**REMARKS TO THE PUD PUBLIC MEETING 4/21/26 9am**  
*Kittitas PUD #1 Proposed Headquarters Relocation SE-26-00003*

*George Thomas, adjacent landowner, active farmer, and commenter SE-26-00003*

A1.0

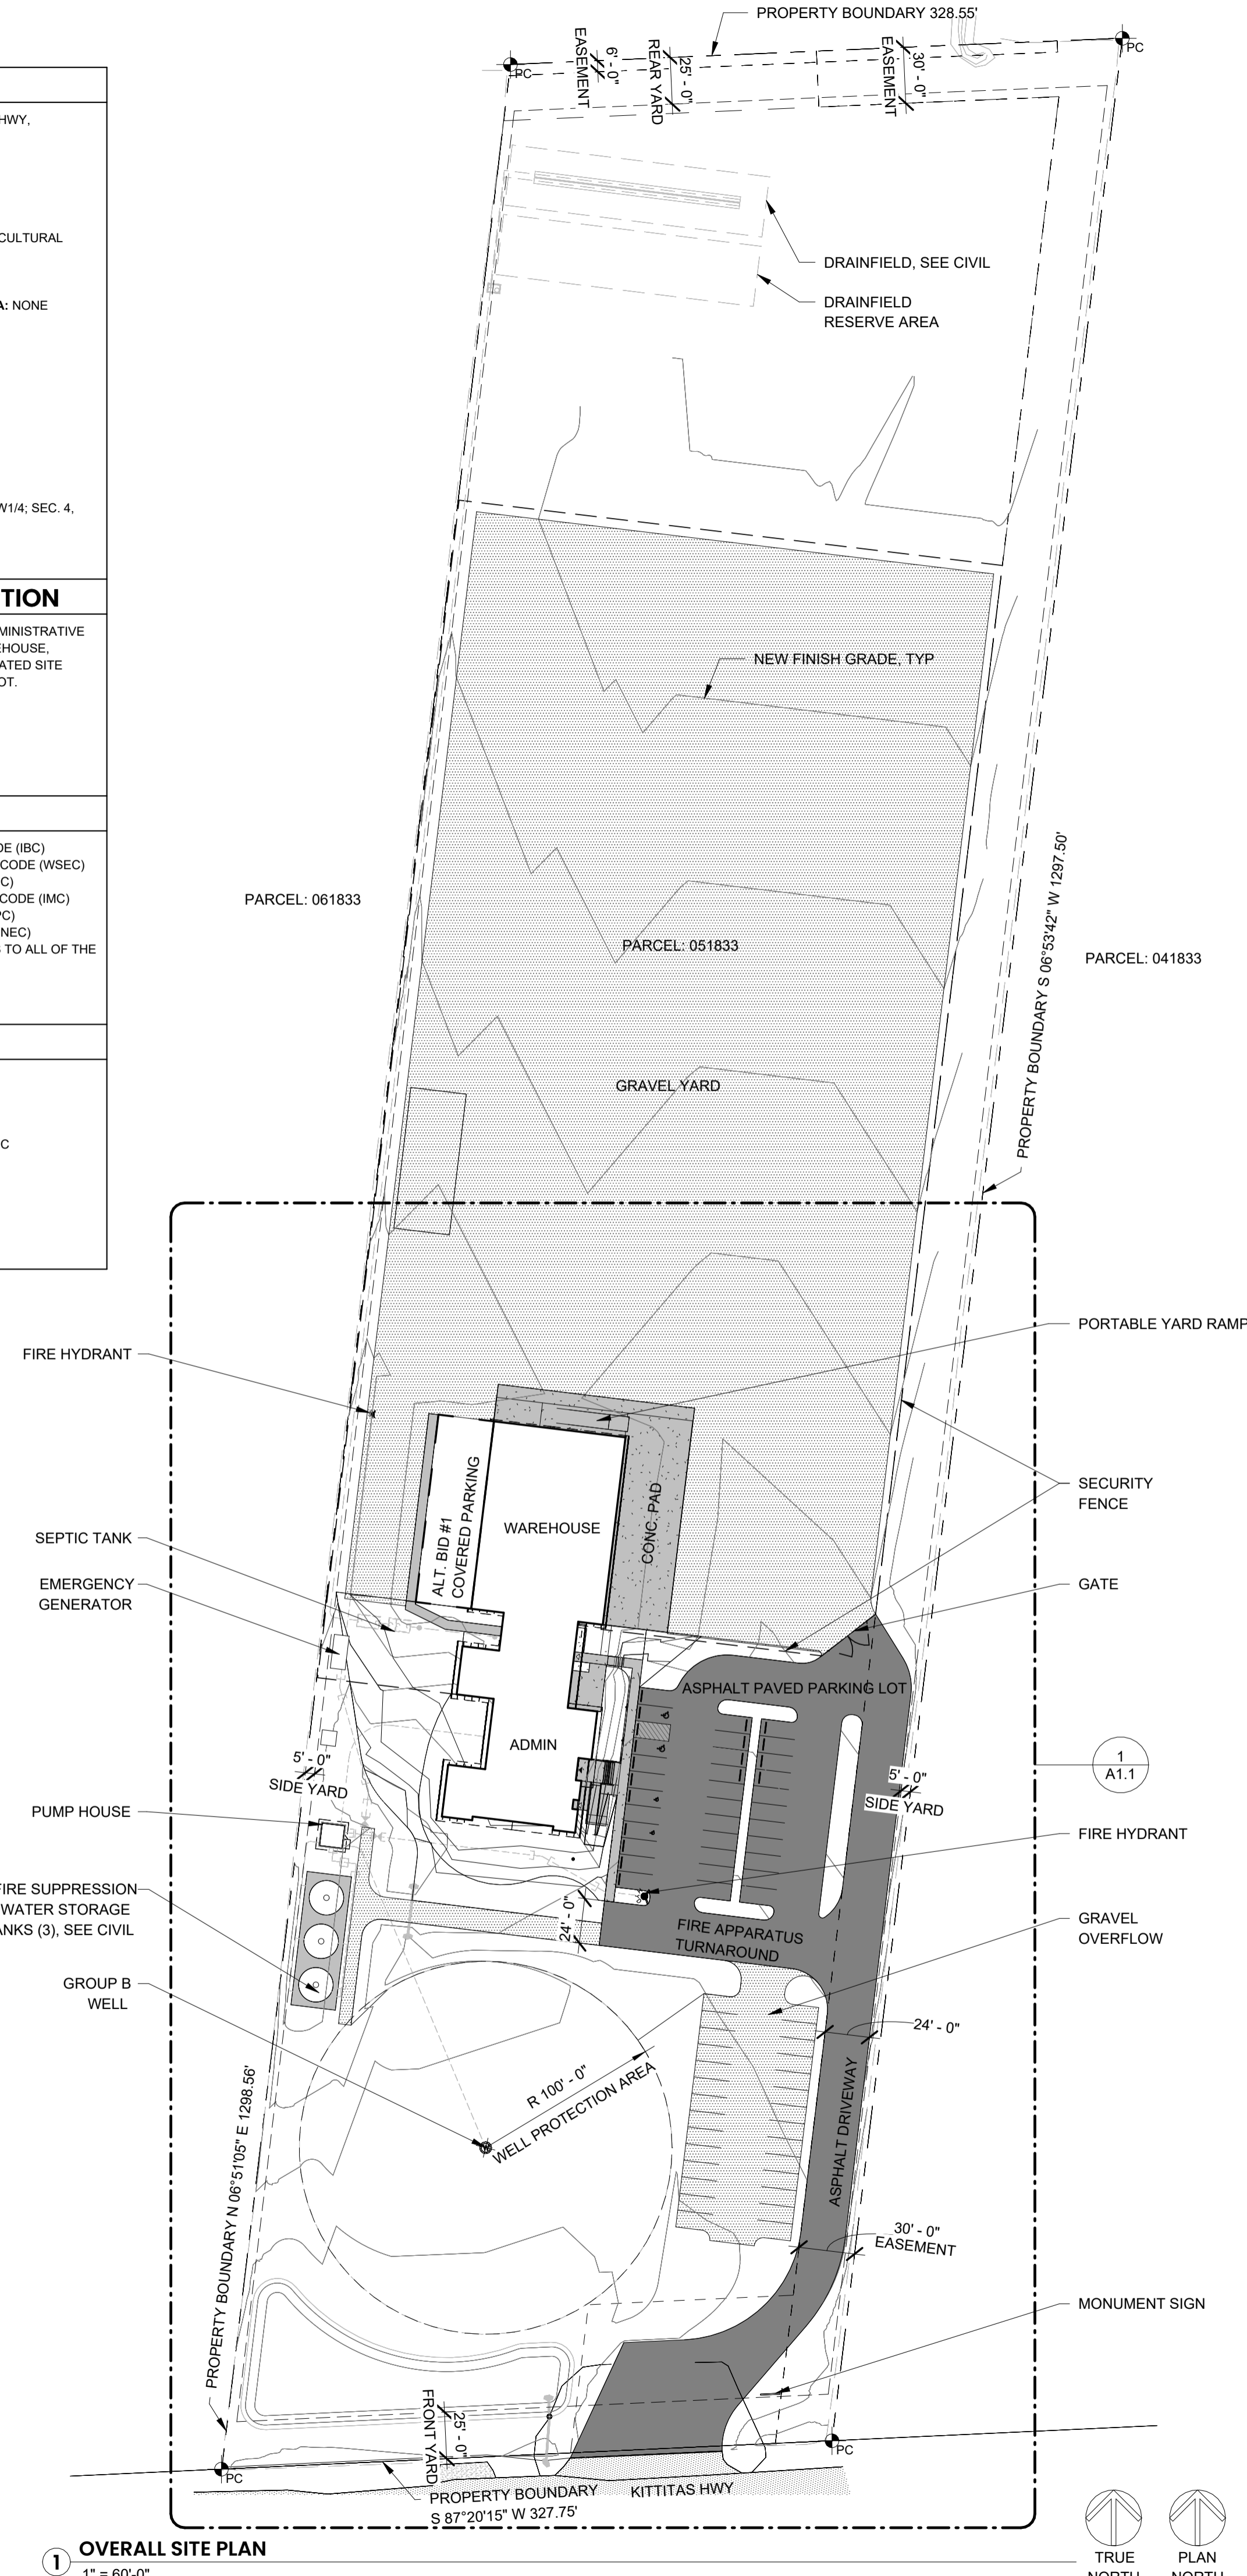
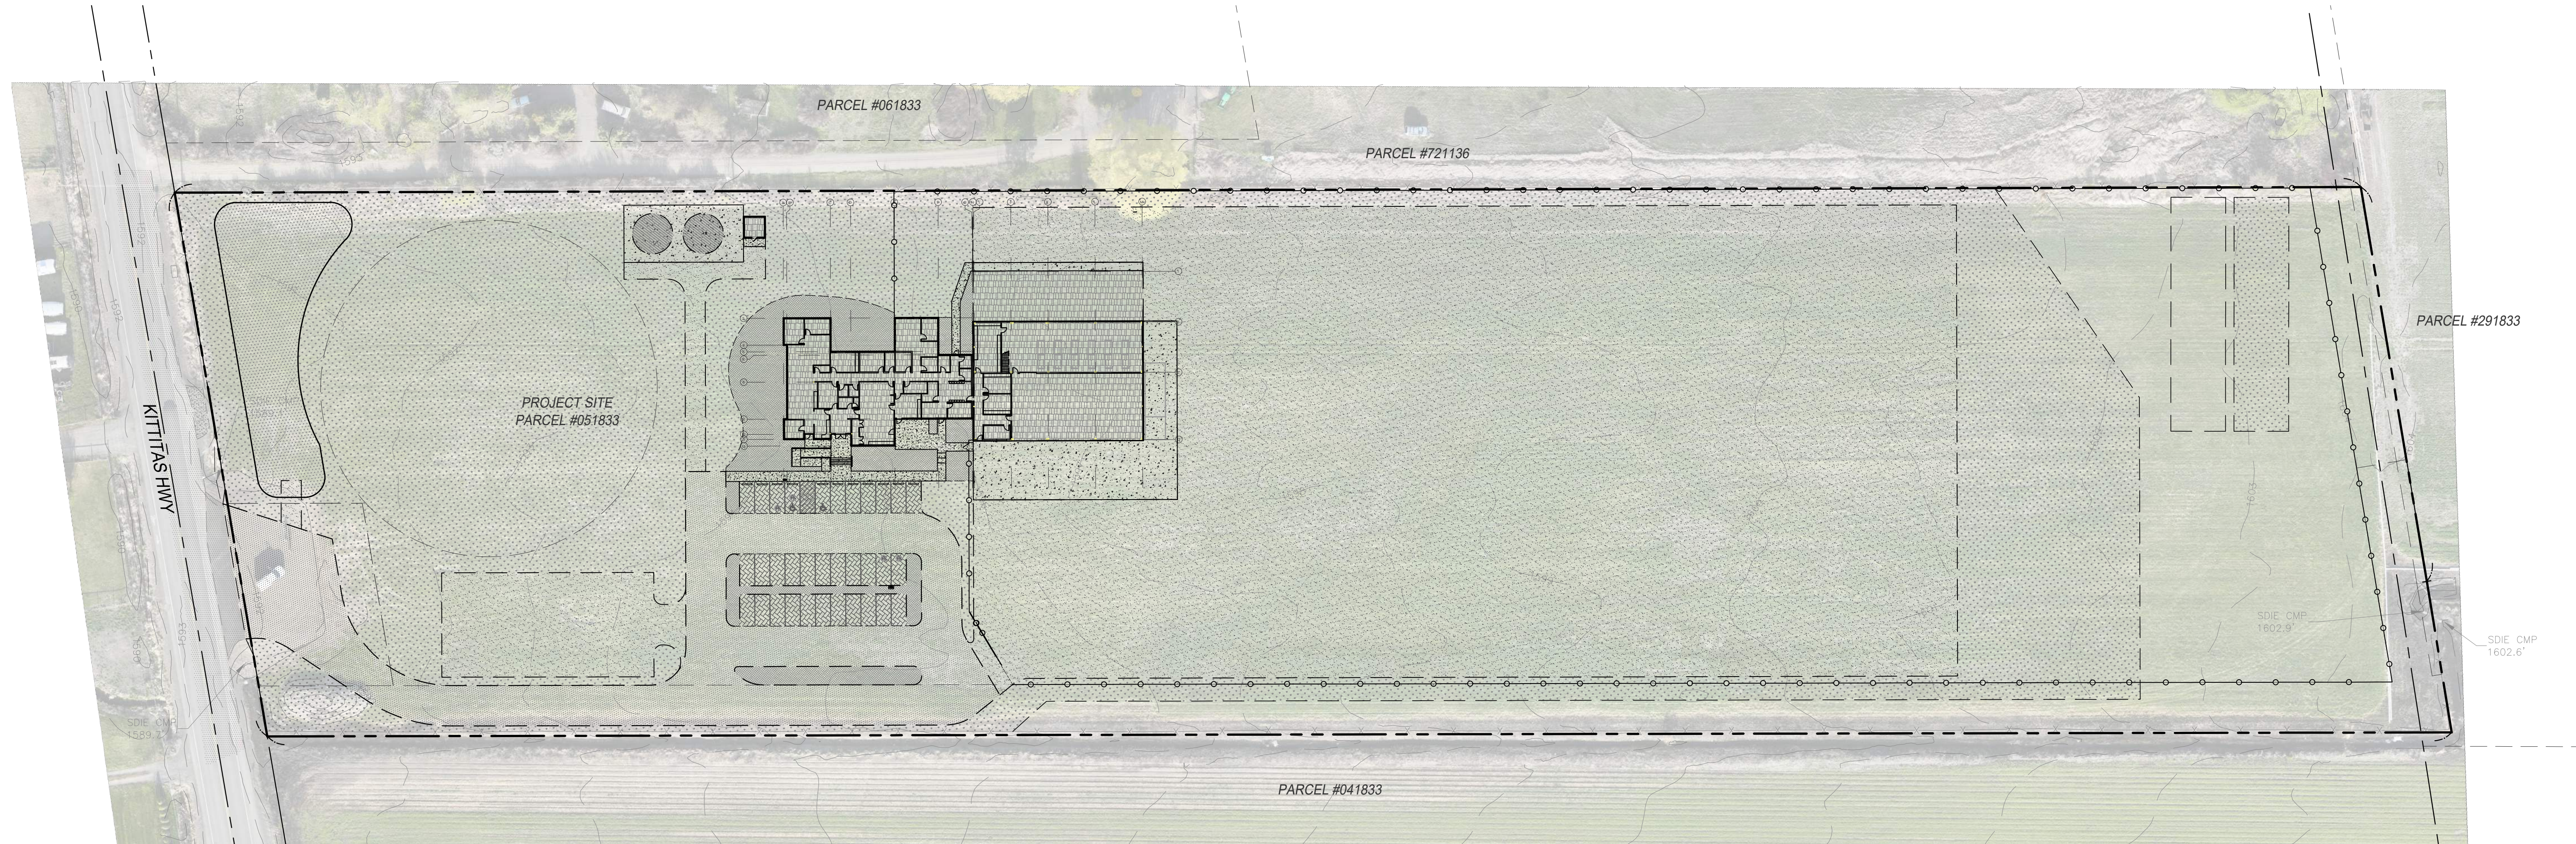
Your own drawings narrow the recorded thirty-foot easement to a twenty-five-foot paved strip. That is a seventeen percent reduction in a recorded width, accomplished without my consent, without a recorded amendment, and without consideration.

Your plan then installs a rigid perimeter fence along the easement corridor, replacing open agricultural access with a hard industrial edge. It introduces a sharp turn at the northeast corner of your parcel a geometry my oversized farm equipment cannot navigate. And in place of the clear passage the instrument guarantees me, it routes my access directly into a drainage ditch. That ditch originates along Ferguson Road, runs north-south, turns east, turns south, and parallels the entire length of your parcel. It overflowed this past winter.

Nothing on this site plan justifies a narrowing, a rigid fence, a sharp turn, or a forced diversion into an overflowing ditch. All four are textbook unreasonable interference. And because the dominant estate holds the controlling property right not the servient estate the decisions about runoff management, access geometry, and any construction activity that touches the easement corridor are mine to approve. Not yours to impose.

**And then there is the soil itself.** Converting this parcel to the proposed facility requires stripping approximately 14,000 cubic yards of Prime Farmland topsoil roughly 1,868 heavy truck trips to haul it out and importing an equivalent volume of aggregate to replace it. The site plan then commits 5.79 acres, 60 percent of the parcel, to permanent industrial gravel. Total impervious surface reaches 53.5 percent.

**Fourth, where those chemicals end up if the checklist is allowed to stand.** Your drainfield and reserve area are sited at the north end of this parcel within 100 feet of a small pond on the adjacent property to the west, and directly downstream of approximately 25 million gallons of annual flood irrigation on the parcel immediately upgradient.

Your site plan shows up to 180,000 gallons of fire suppression capacity. At 275 gallons per day, filling those tanks takes 655 days. The water source is not in the record.

Under NFPA 22, tank capacity must reflect actual fire demand. A 6,300-square-foot office does not require 180,000 gallons. That volume is consistent with protecting a materials yard, storing the chemicals I just listed which your checklist says are not there.
